Address: 3 Hyrst Garth Batley WF177AD

Application number: 2024/91900	
What is the application for?:	Erection of single storey side and rear extensions and loft conversion with rear
Address of the site or building:	1, Hyrst Garth, Batley, WF17 7AD
Postcode:	WF17 7AD

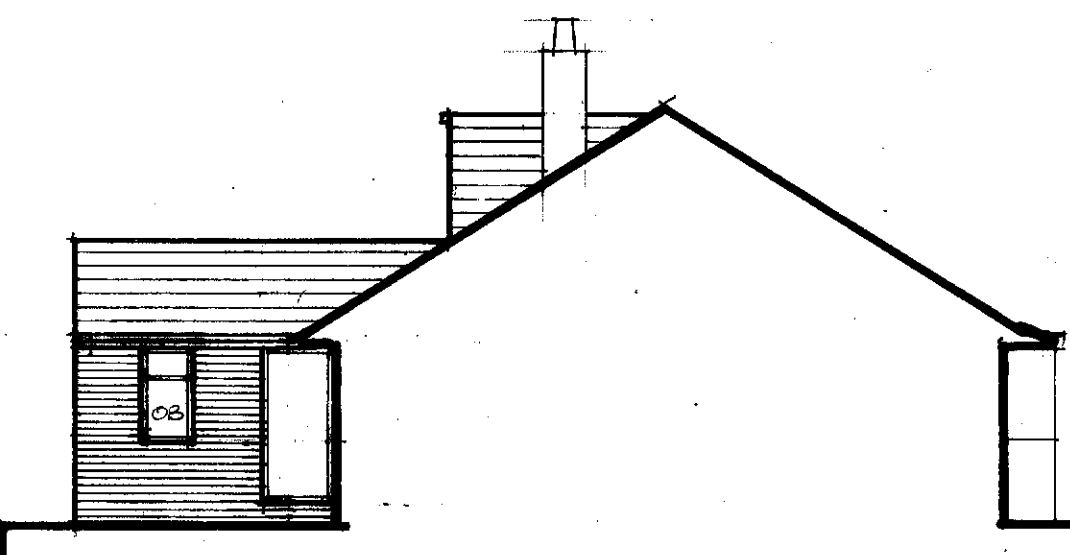
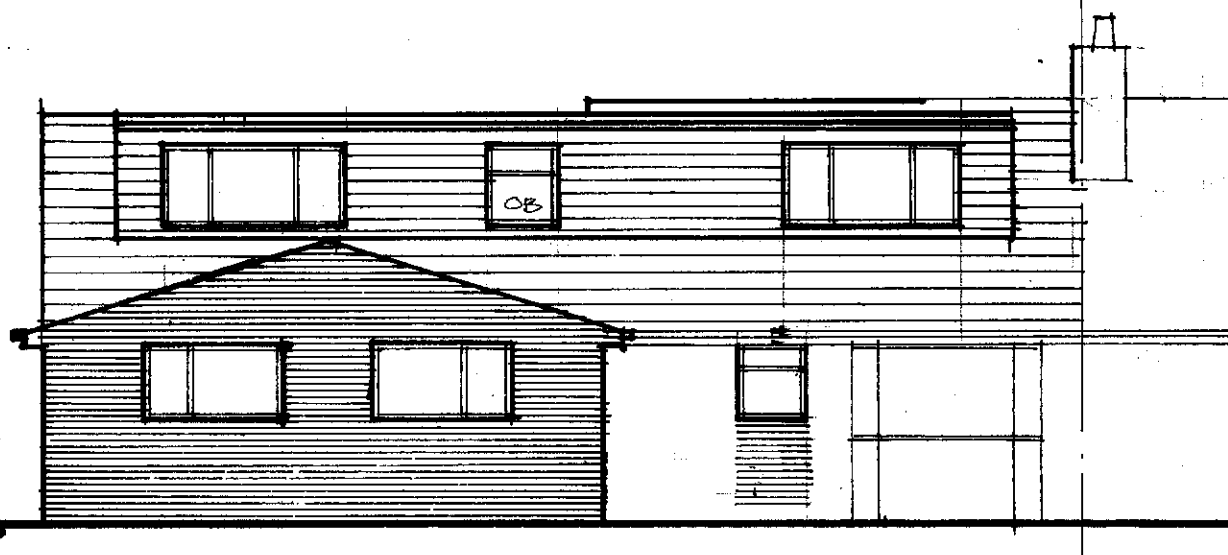
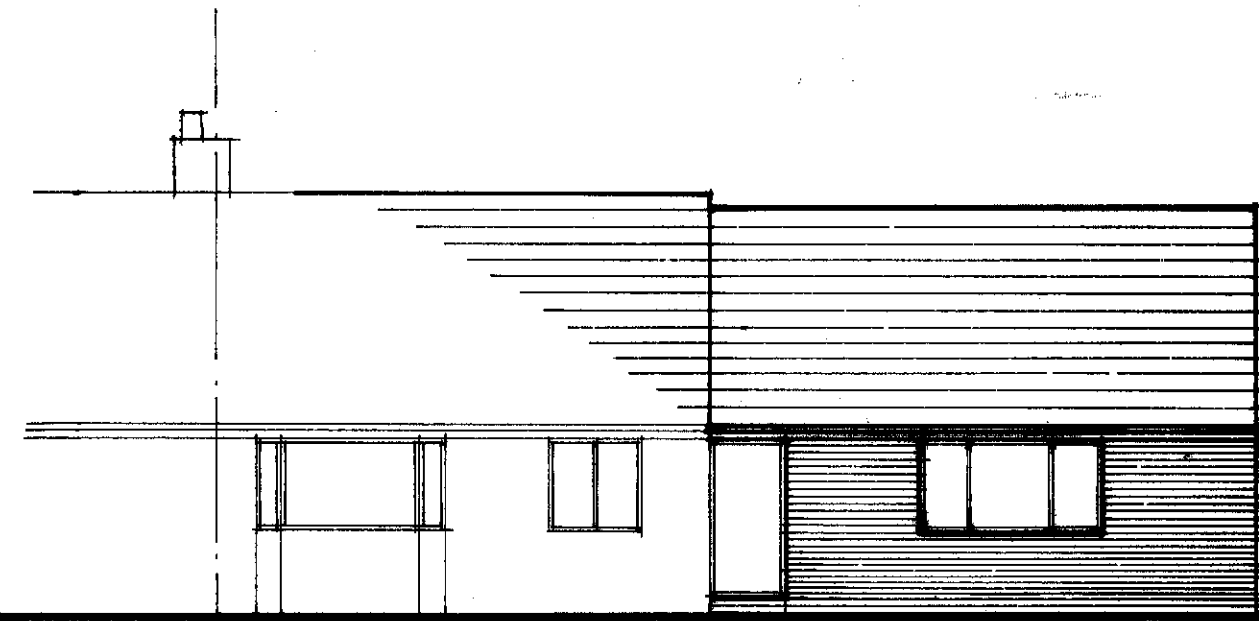
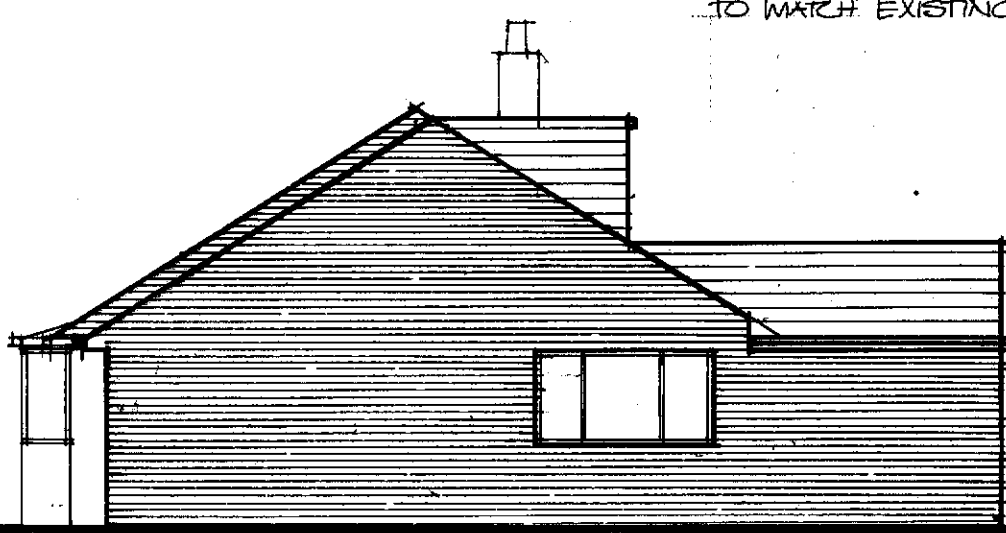
Type of comment: A general comment	
Do you wish your comments to be published on the website anonymously?	No
BUNGALOWS: These small 2 bedroom semi-detached bungalows were built in the late 1950's for the retired/small families. There is a shortage of such homes as the ageing population down-sizes. From the plan the size and appearance will change significantly. NEIGHBOURHOOD: I have lived here over 30 years, and now , this quiet, peaceful location is much appreciated. The possibility of change due to the attached expansion of the building is a concern. PARTY WALL My home at no.3 shares a wall with the property seeking an extension, a loft conversion, and rear dormer. I have seen the plans but not the dimensions. My understanding is that the extension is at the far end from me i.e. Track Road side which is better for me. So I believe the party-wall issues are concerned with the Loft changes. This is very important. I have not received a Party-Wall Notice for confirmation of work to be done. I would also seek a Party-Wall Agreement for the same. NOISE: A major concern is unacceptable noise. These bungalow walls are very thin so noise travels easily from next door. e.g. banging doors.The occupiers should realise this and co-operate by due care for mutual benefit. The use made of the Loft conversion will be very important. Inevitably larger families after expansion could increase noise potential. AESTHETICS Will the planned changes fit well with the existing visual character of the neighbourhood. Unless designed accordingly the appearance could be incongruous with the row of semi-detached bungalows on the south side of Hyrst Garth.
